ASSESSMENT REPORT

Section 75W Modification Vincentia District Town Centre (MP06_0025 MOD 6)

1 ELEVATION
WEST ELEVATION - MOONA CREEK ROAD

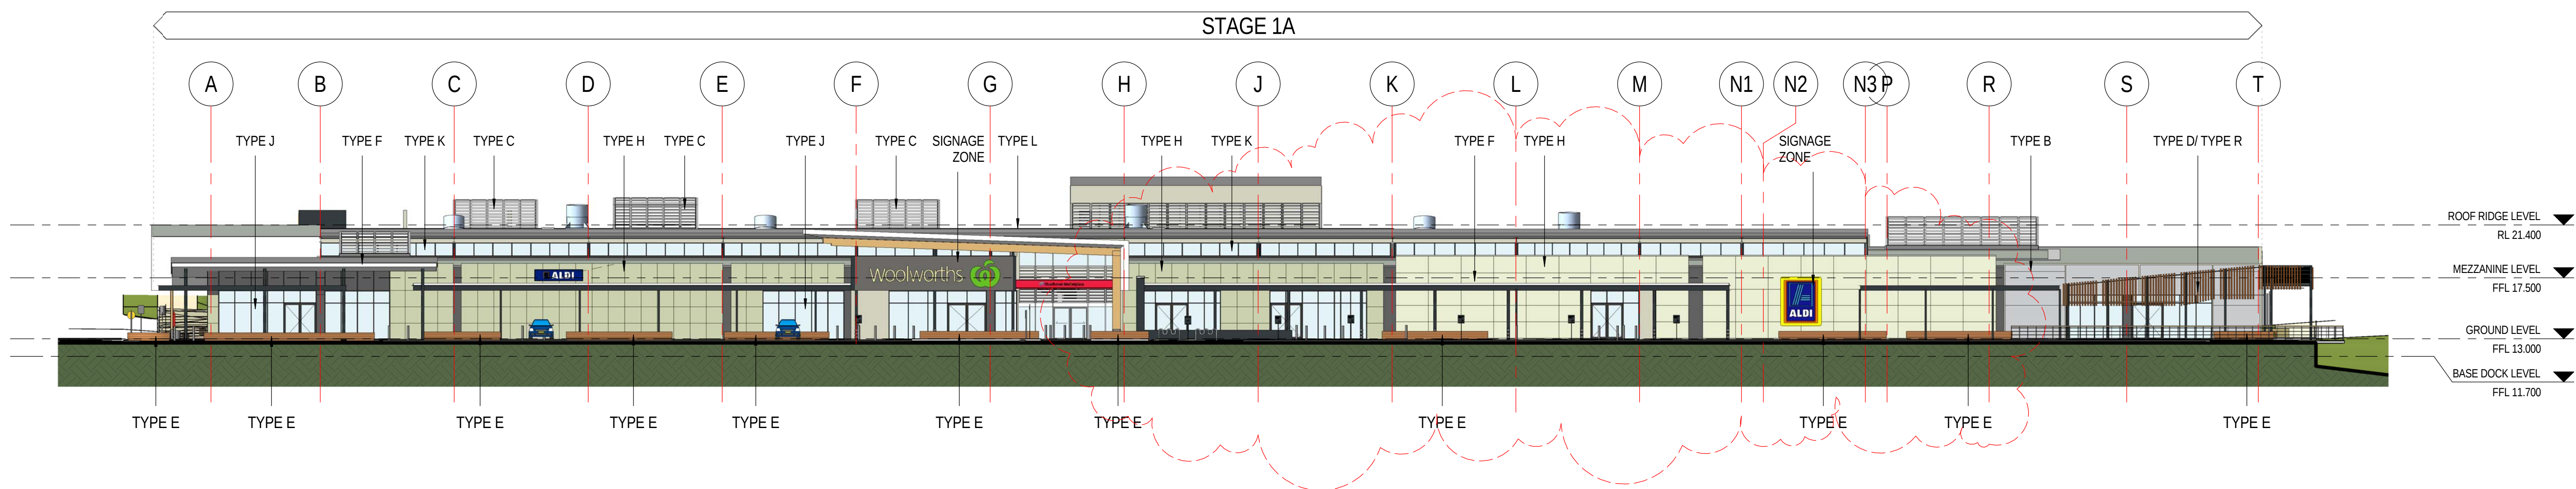
The submissions from the Council and the Ratepayers Association raised concern with the level of activation and streetscape appearance of the Moona Creek Road facade.

The two retail tenancies on the Moona Creek Road frontage that would be deferred to Stage 1b provide activation and visual interest to the Moona Creek Road streetscape and assist in ensuring compliance with the design excellence provisions of the Concept Plan. However, in the absence of these retail tenancies, it is necessary to ensure that the streetscape appearance of Stage 1a as viewed from Moona Creek Road is acceptable.

In order to ensure design excellence is provided up until the Stage 1b works are commenced, the Proponent has amended the application to provide temporary architectural treatments including textured and painted concrete panels, corrugated metal cladding, and weathered timber planks and battens.

Given the above, the Department is satisfied that the application includes suitable measures to demonstrate that the temporary works proposed in Stage 1a are capable of exhibiting design excellence until such time at the Stage 1B works are implemented. Notwithstanding, as previously outlined, the Department has recommended the imposition of a condition requiring the construction of the Stage 1b works prior to the issue of a Construction Certificate for the Stage 2 works, to ensure that the design treatments required to activate the Moonah Creek Road frontage under MP 06_0025 MOD 5 will be constructed.

Typical Section - Moona Road - Development

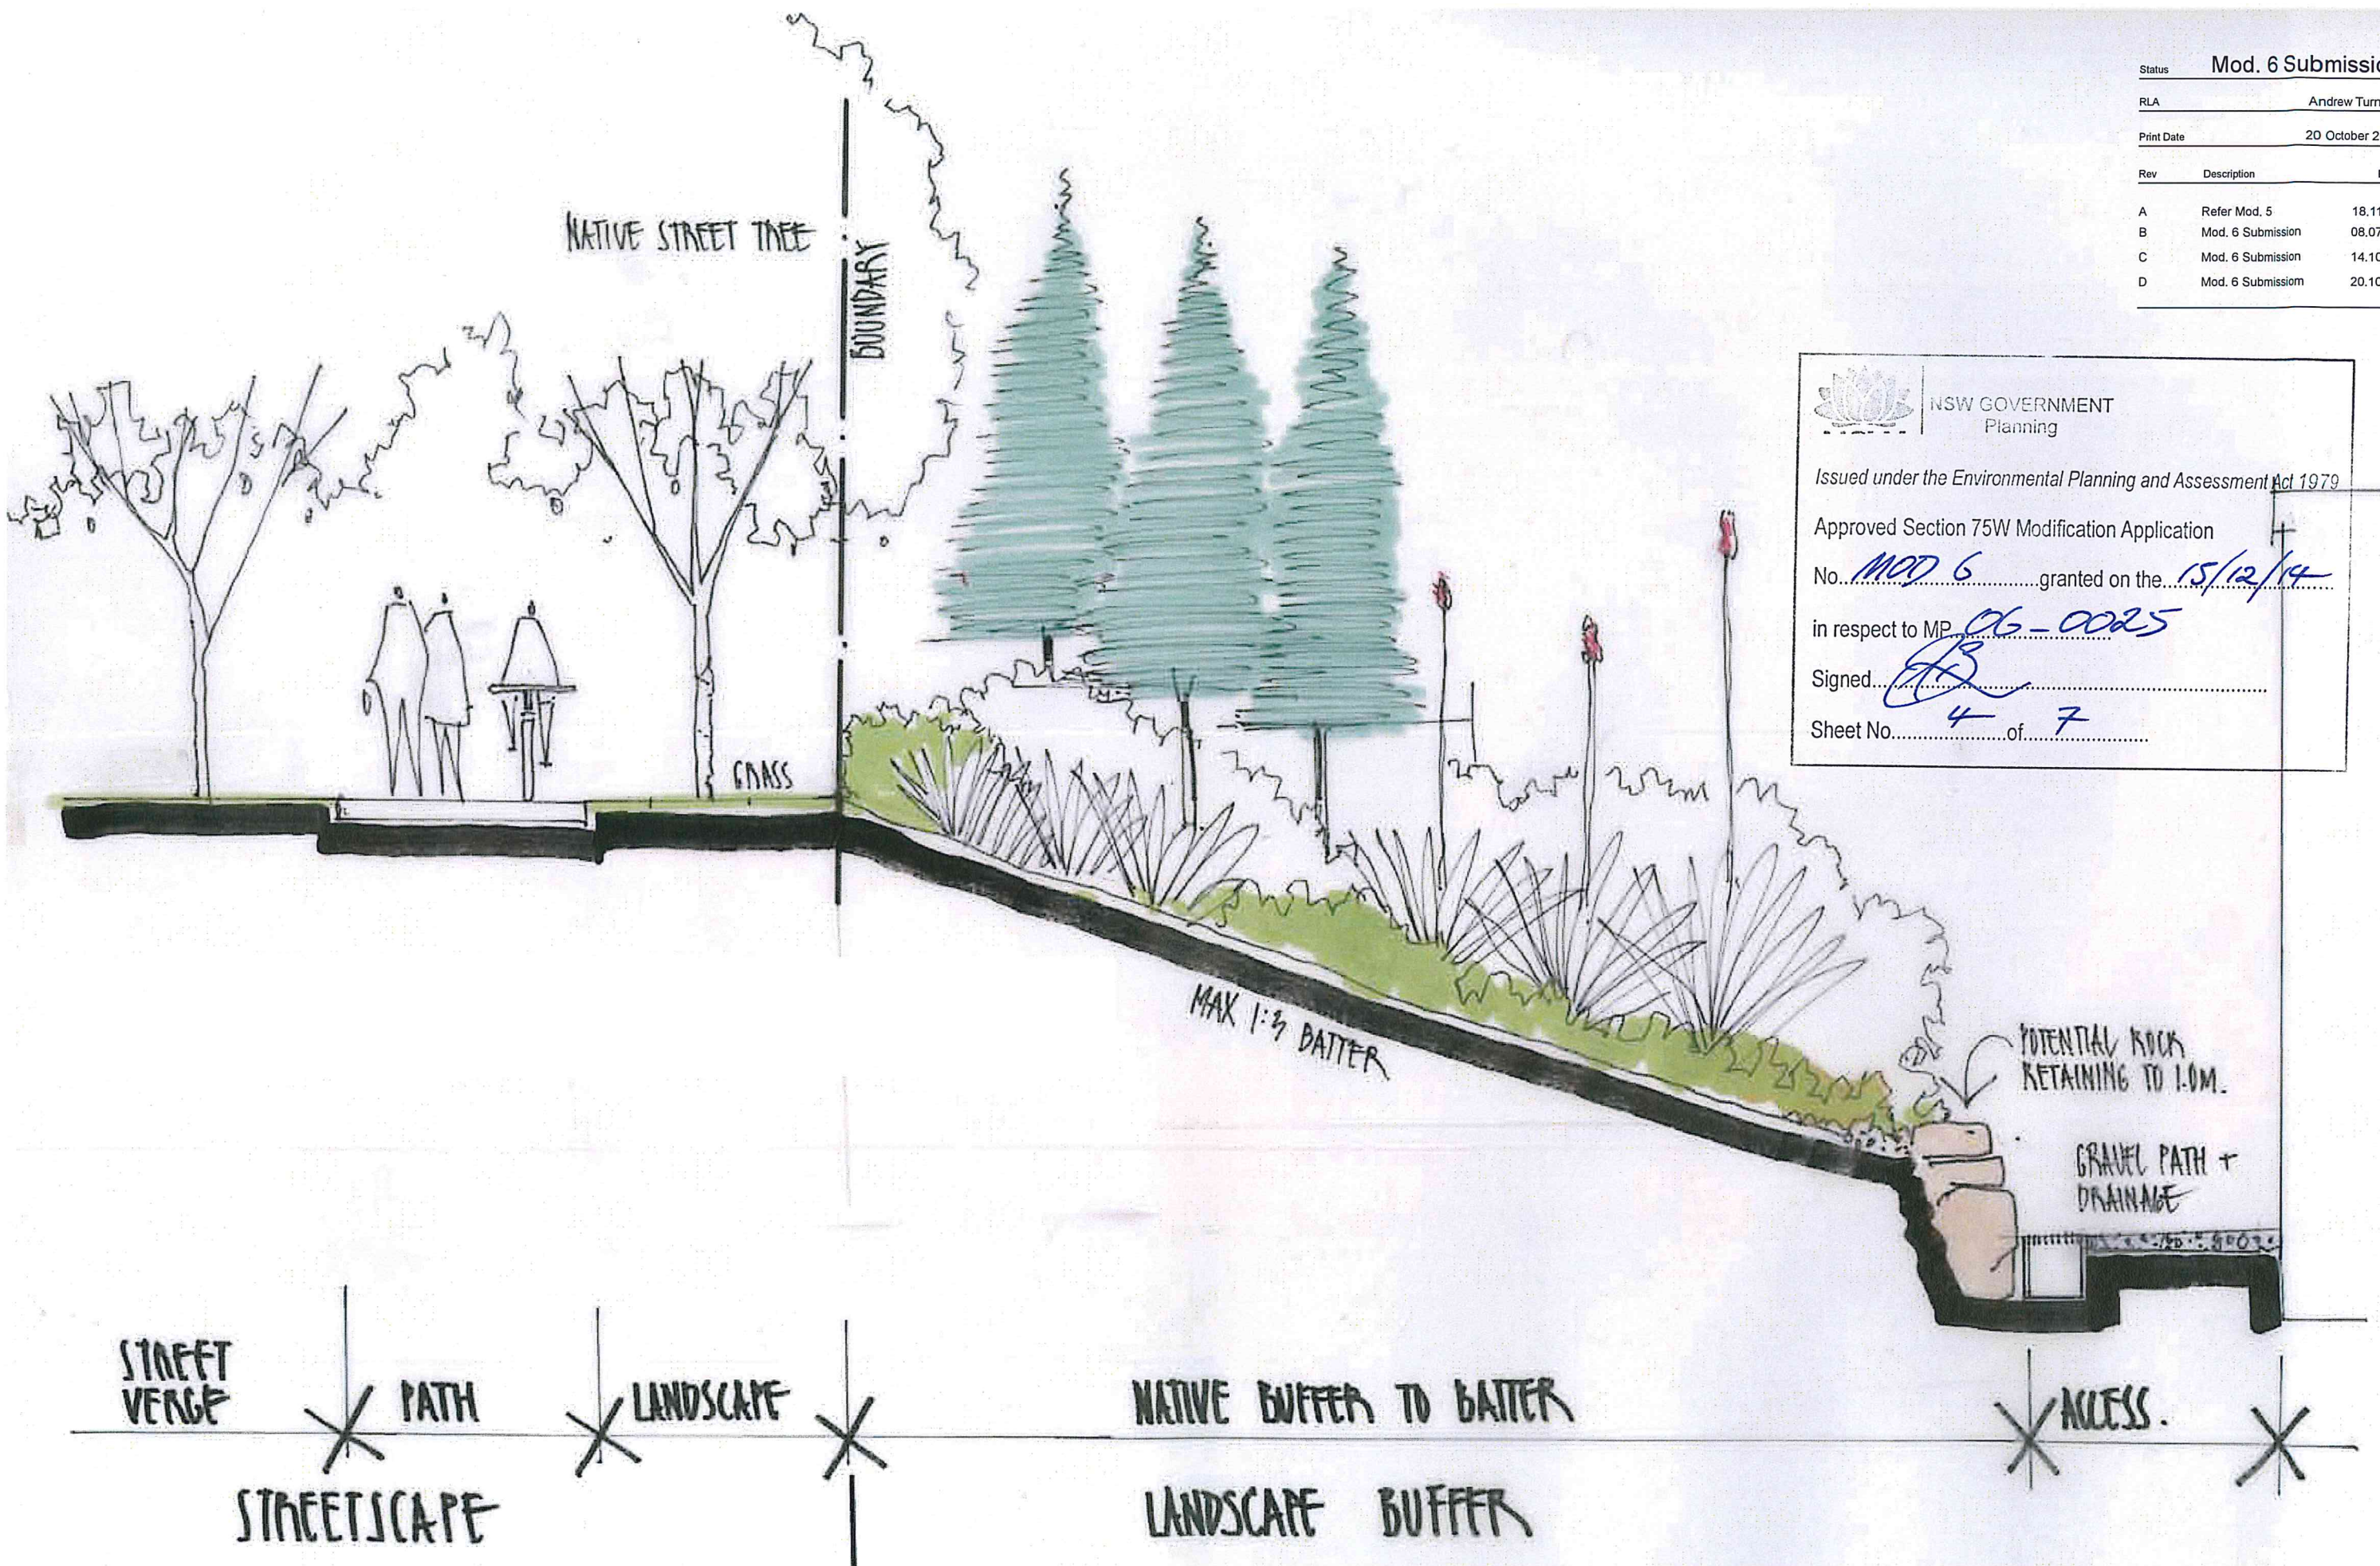
- the streetscape appearance and activation of Moona Creek Road;
- the adequacy of the proposed landscape treatment to screen the development from Naval College and Moona Creek Road;
- whilst not part of the application, the proposed plans do not show a connection between the shared pathway on the southern side of The Wool Road and the subject site. The lack of connection is a safety issue for school children and pedestrians seeking to access the district centre from The Wool Road;

In addition, the RTS includes revised landscape drawings which demonstrate that the appearance of the centre as viewed from Moona Creek Road will be softened through temporary landscaping up until the Stage 1b works commence.
